**RE: Encanto Apartments – Bldg. E
2500 Eastman Crossing SE
Temporary Certificate of Occupancy
Engineer's Certification Date: 6/17/24
Engineer's Stamp Date: 3/7/22
Hydrology File: R16D101**

Based on the Engineer's Partial Grading and Drainage Certification received 06/25/2024 and site visit on 6/27/2024, this letter serves as a "green tag" from Hydrology Section for a 30-day Temporary Certificate of Occupancy for the Encanto Apartments, Building E to be issued by the Building and Safety Division. The following comment needs to be addressed prior to acceptance for Permanent C.O. of the above referenced project:

GRADING AND DRAINAGE PLAN
SHEET 4 - NW
ENCANTO APARTMENTS
MESA DEL SOL
MARCH, 2022

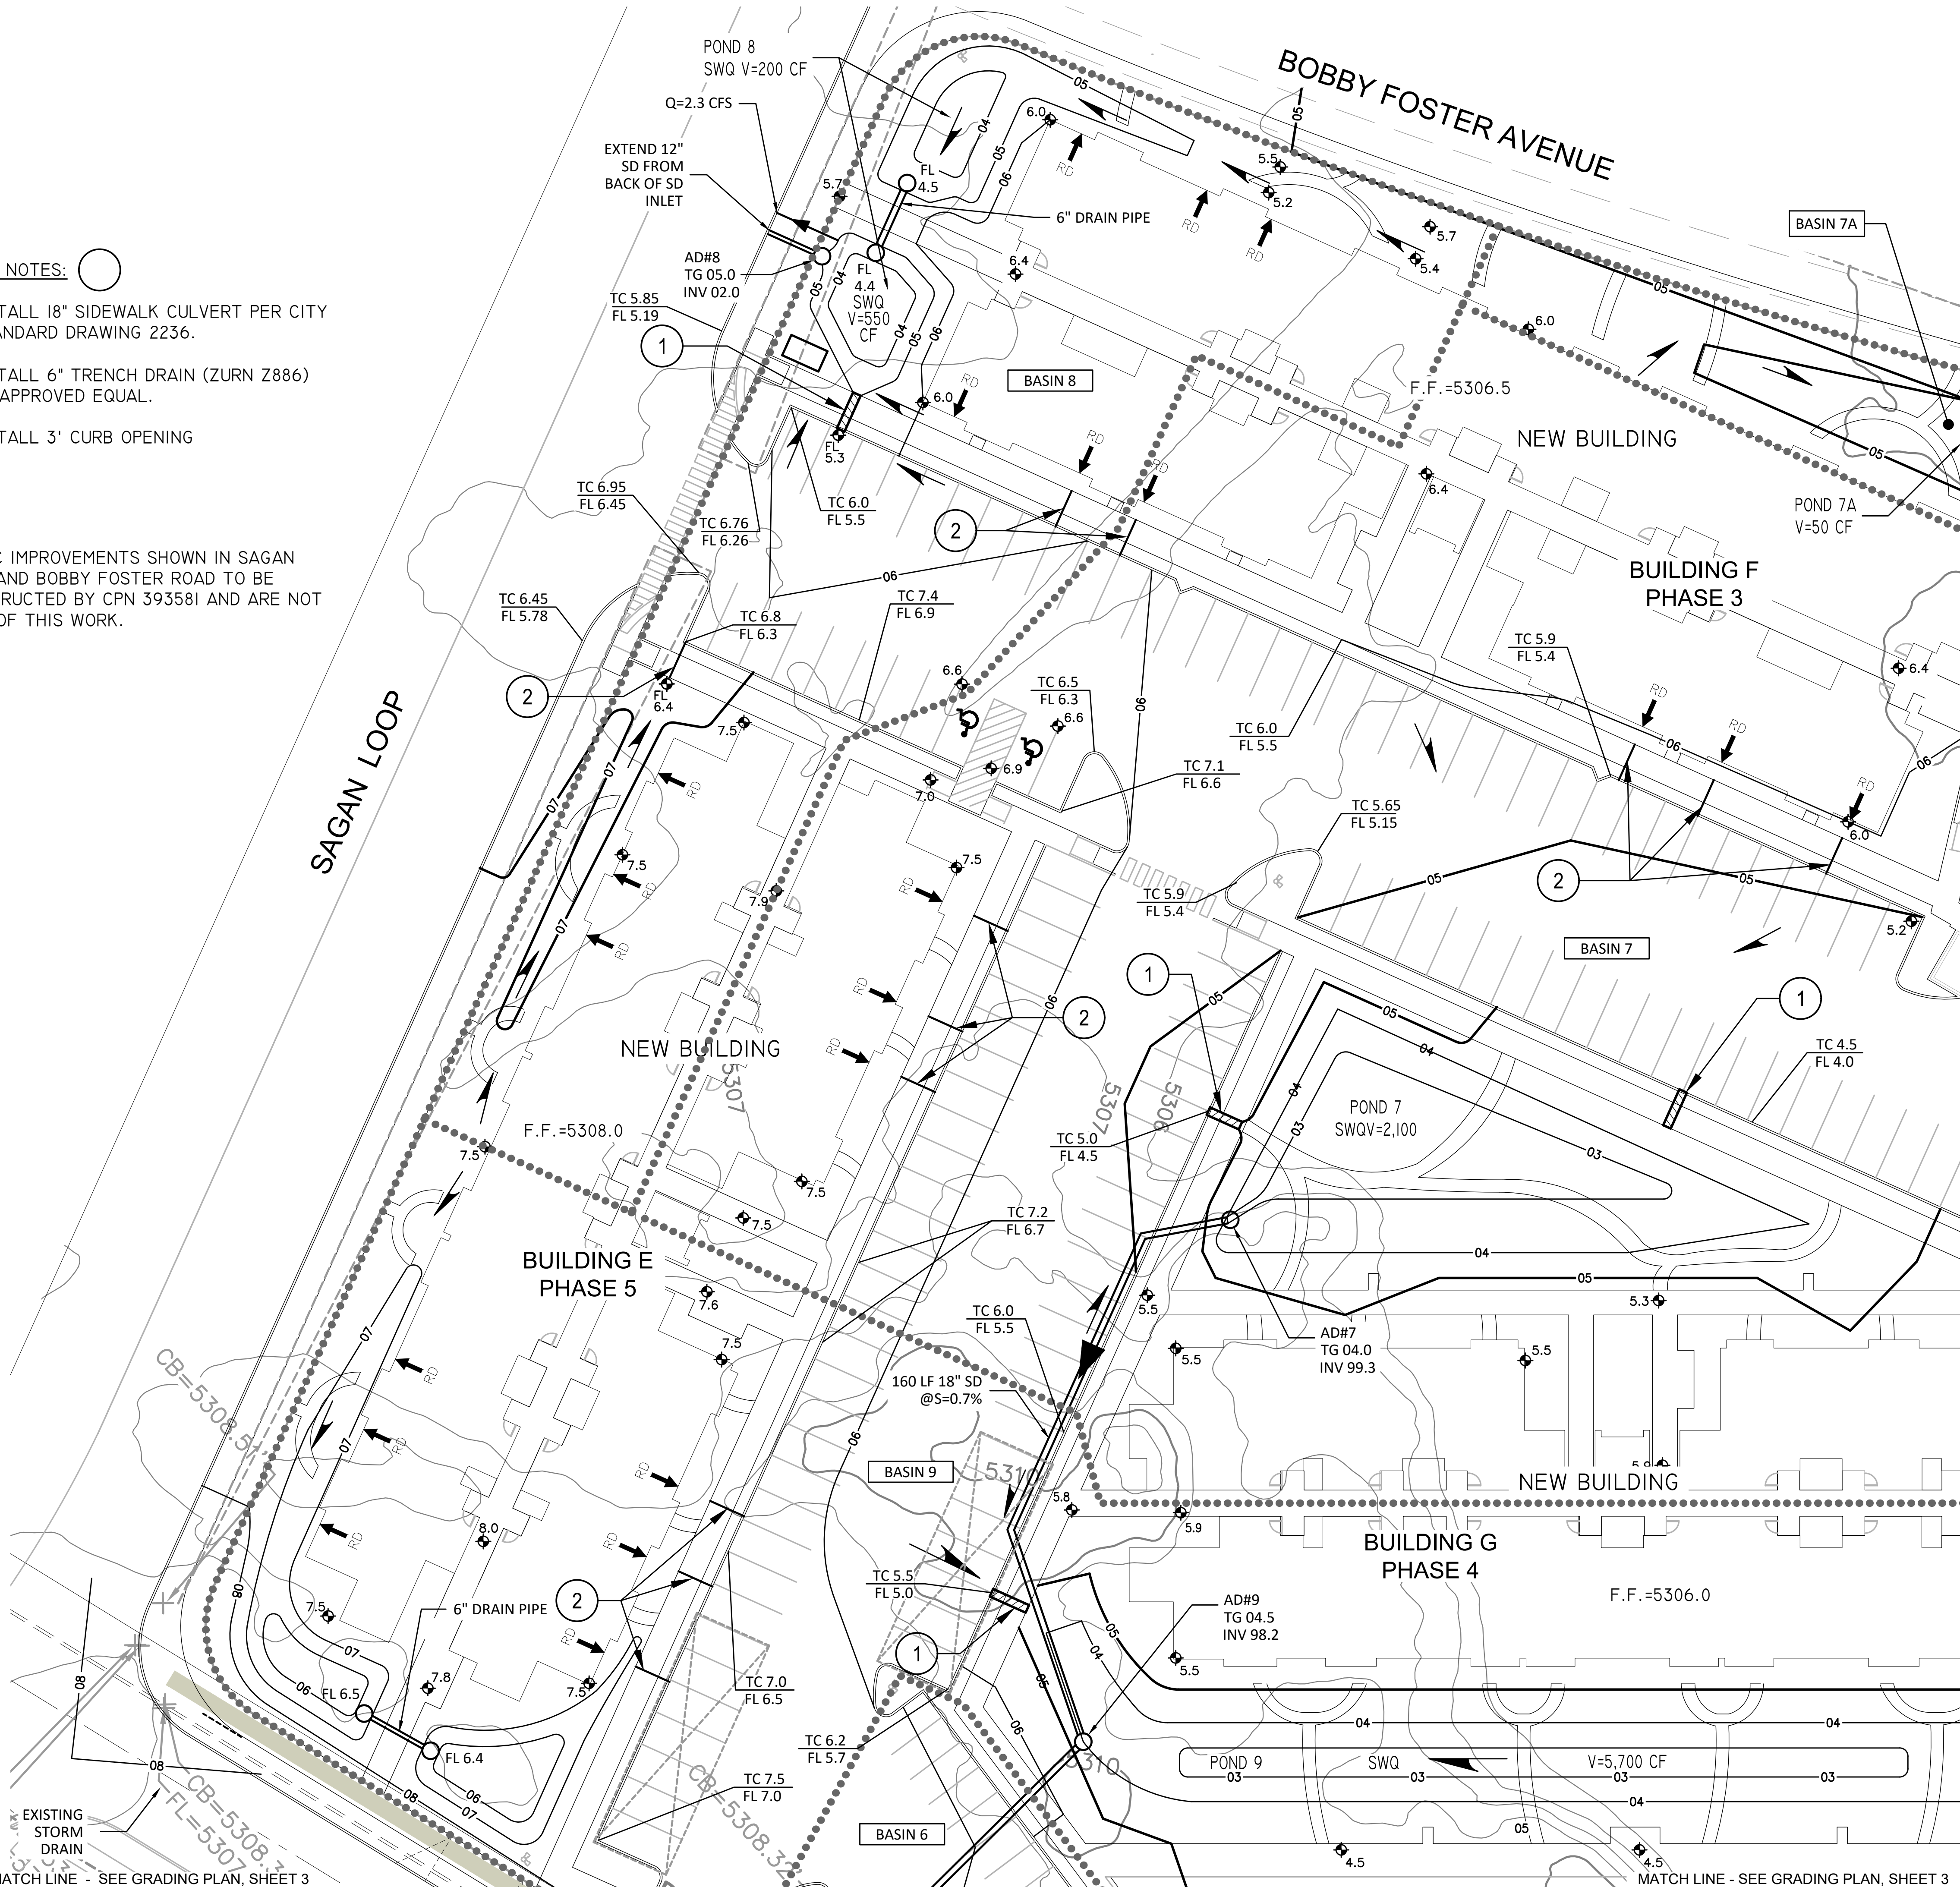
Install the steel plates on all of the sidewalk culverts where they are missing in the area and provide proof of installation to Hydrology when complete.
